Recommendation Report for Planning Permission for Works or Extension to a Dwelling

REF NO: M/98/25/HH

LOCATION: 1 Elmer Court
Elmer
Middleton-on-sea
PO22 6JT

PROPOSAL: Extension and alterations to form a rear facing balcony and sliding doors (part retrospective).

06 SIDE (EAST) ELEVATION:

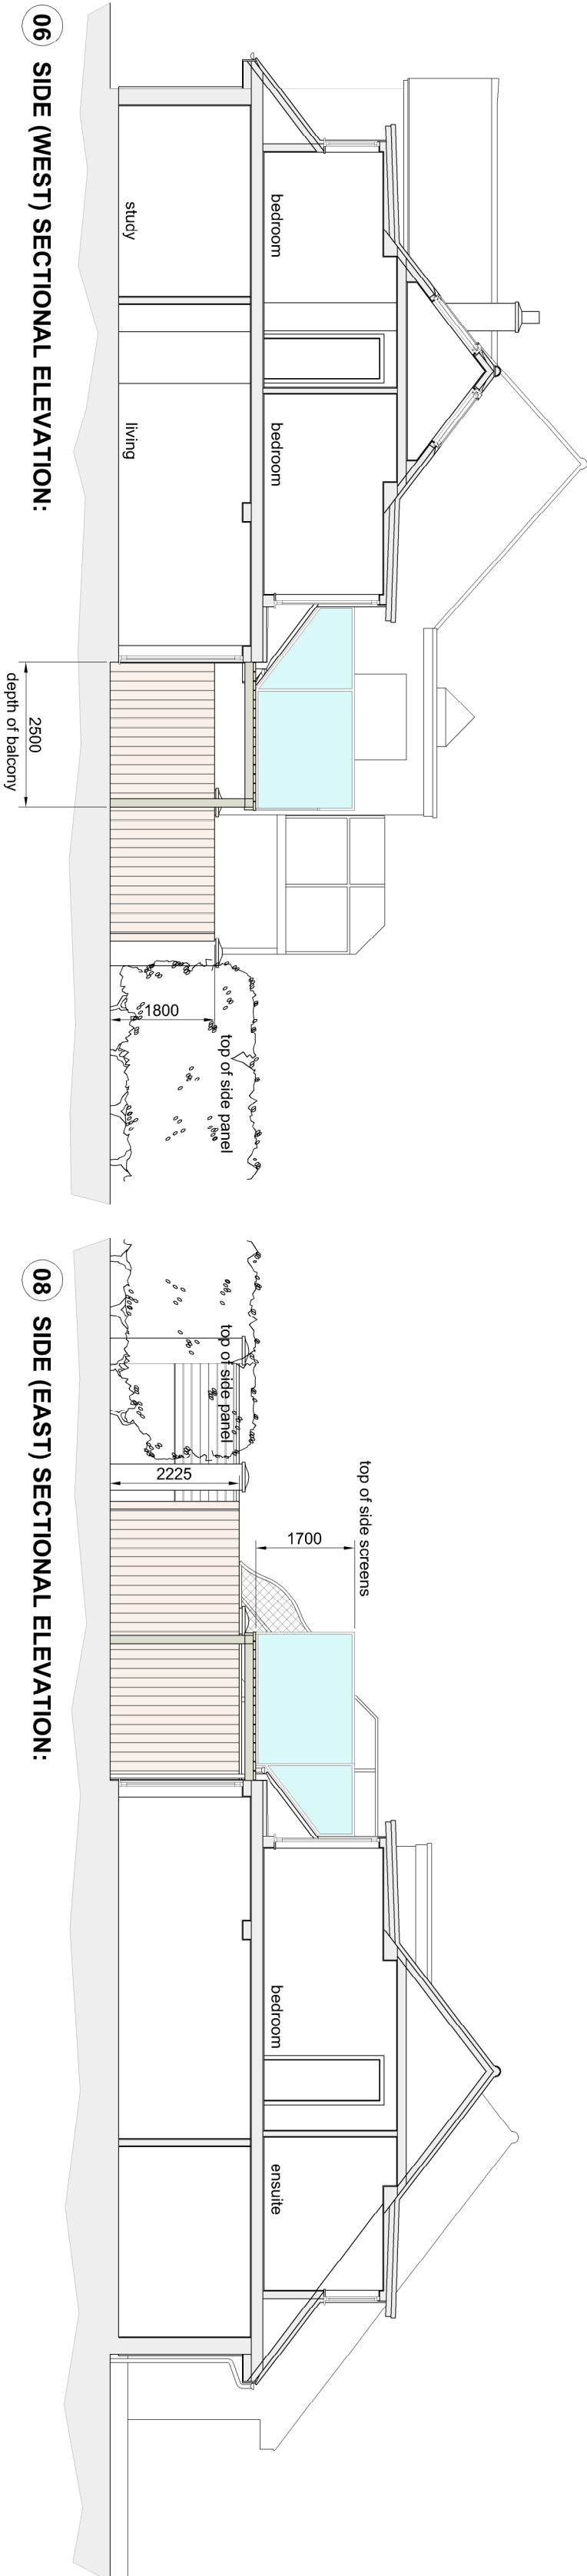
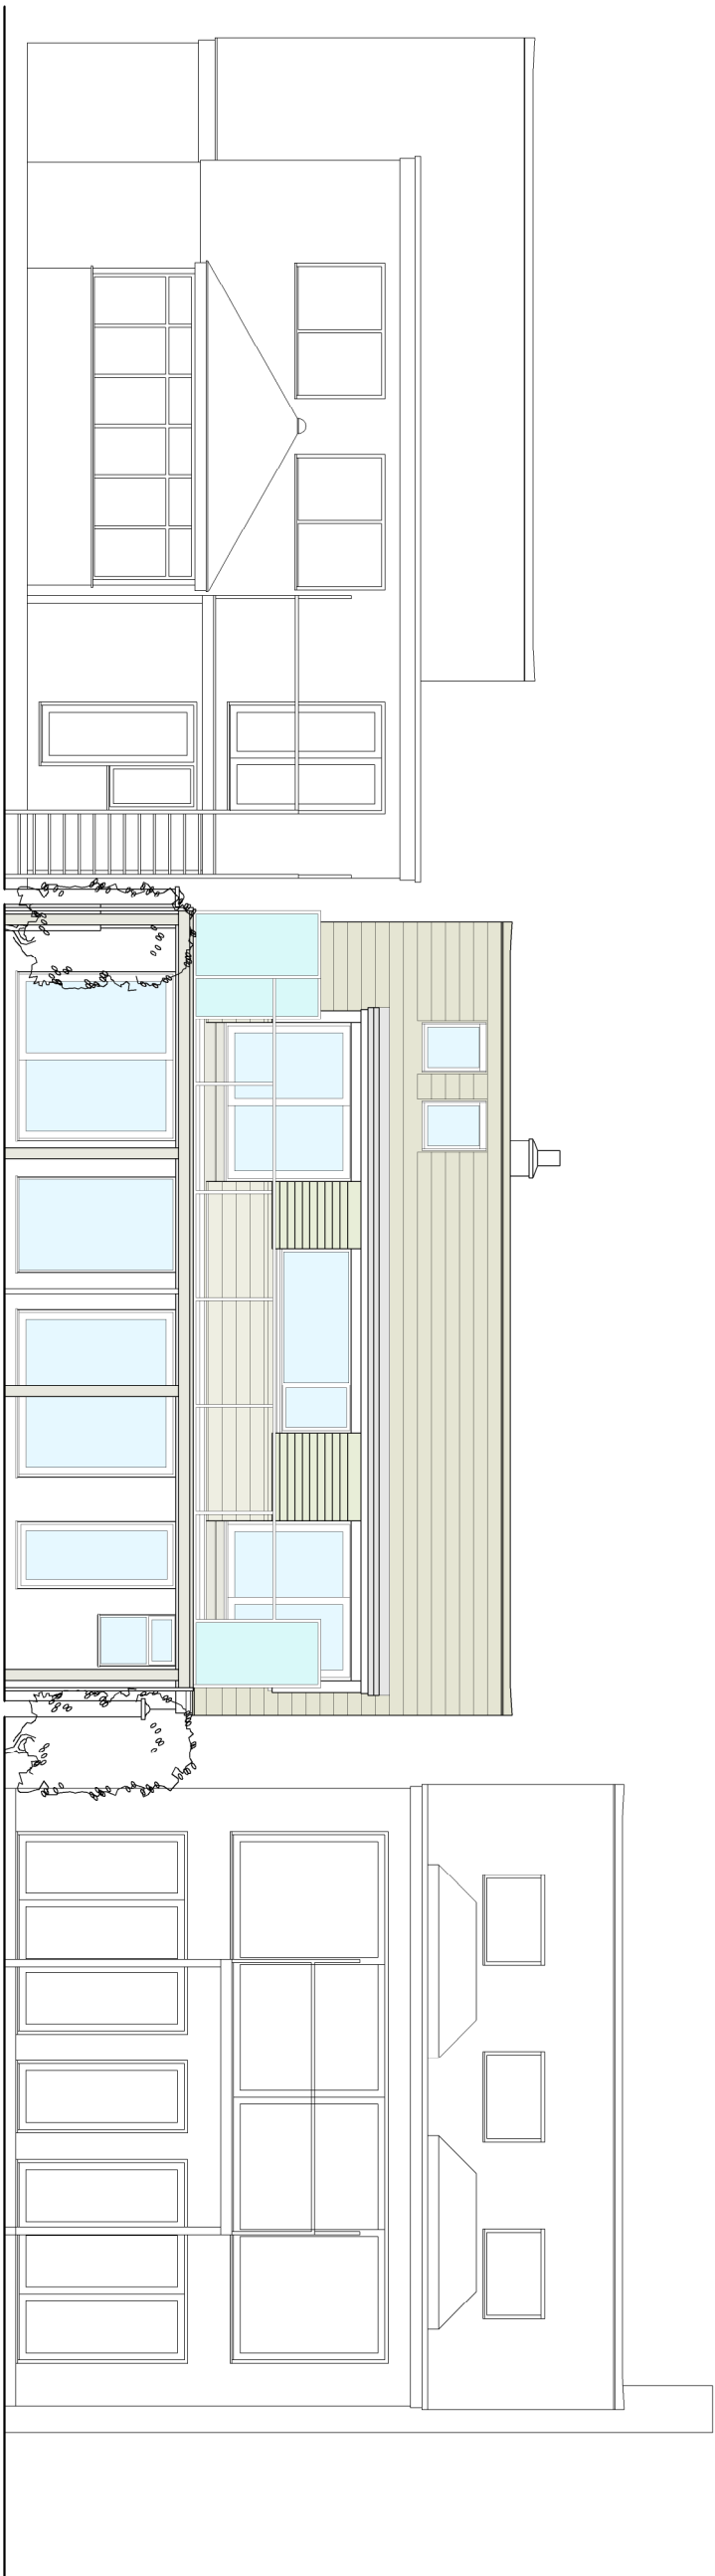
Regarding inaccurate plans, clarification has been sought from the planning agent and matters resolved through clarification that the resultant minimal reduction in width is due to the removal of the timber uprights.

The proposed balcony would measure 10.3m in width and 3.4m in depth. Fixed obscurely glazed side screens would be constructed to the eastern and western sides of the balcony, measuring 1.7m high and would return 0.9m in the south east and south west corners. The balcony would be facilitated by the reduction in depth of the existing pergola style canopy extension to the rear, which would extend no further than the proposed balcony. The single storey structure would be constructed from timber, with a metal and glass balustrade surrounding the balcony. The use of glass balustrades would minimize the visual impact of the proposal, particularly compared to the previously refused timber side panels. Furthermore, it is noted that the proposed screening and balustrading would be similar to that surrounding the balconies of immediate neighbouring properties. While it is noted that the proposed balcony is wider than its adjacent neighbours, there are a number of similar examples along this stretch of coastline within Elmer. As identified by the Planning Inspector in dismissing the appeal (reference APP/C3810/D/25/3362664) following the previously refused scheme (M/100/24/HH), balconies form a prominent and established feature of this area, and the introduction of this balcony would not appear out of place within its surroundings.

The proposed single storey structure and balcony would be set in 0.2m from the western side boundary and would project 1.1m further in depth than the neighbour's balcony on that side. There is also an external staircase serving the neighbouring balcony, located close to the shared boundary with the application site which it would not extend beyond. To the east side, the proposal would be set in 0.3m and would extend directly in line with the existing rear wall of this neighbour, with the neighbouring balcony extending 2.4m further in depth. The proposed balcony would result in some increased overlooking and an increase in the perception of overlooking of the rear gardens of the property's neighbours to the east and west. To mitigate this, the eastern and western sides of the balcony and 0.9m across the rear elevation of the balcony from the corners, are proposed to be screened with obscurely glazed panels with a height of 1.7m, and a condition is attached to this planning permission to ensure the screening is installed prior to first use of the balcony and retained in perpetuity to prevent excessive and harmful overlooking of the rears of the neighbouring properties to the east and west. Therefore, the balcony does not unacceptably compromise the privacy of neighbouring dwellings.

It is noted that the neighbouring property, No.2 Elmer Close, has a first-floor side window that directly faces the application site, however this window is obscurely glazed. Due to this treatment, it would not experience any adverse impact on privacy as a result of the proposal.

- 3 Prior to the first use of the balcony hereby permitted, fully obscured screening to a height of 1.7m shall be installed along the eastern and western sides of the balcony, and the south eastern and south western returns along the rear of the balcony. This arrangement shall be permanently retained thereafter.
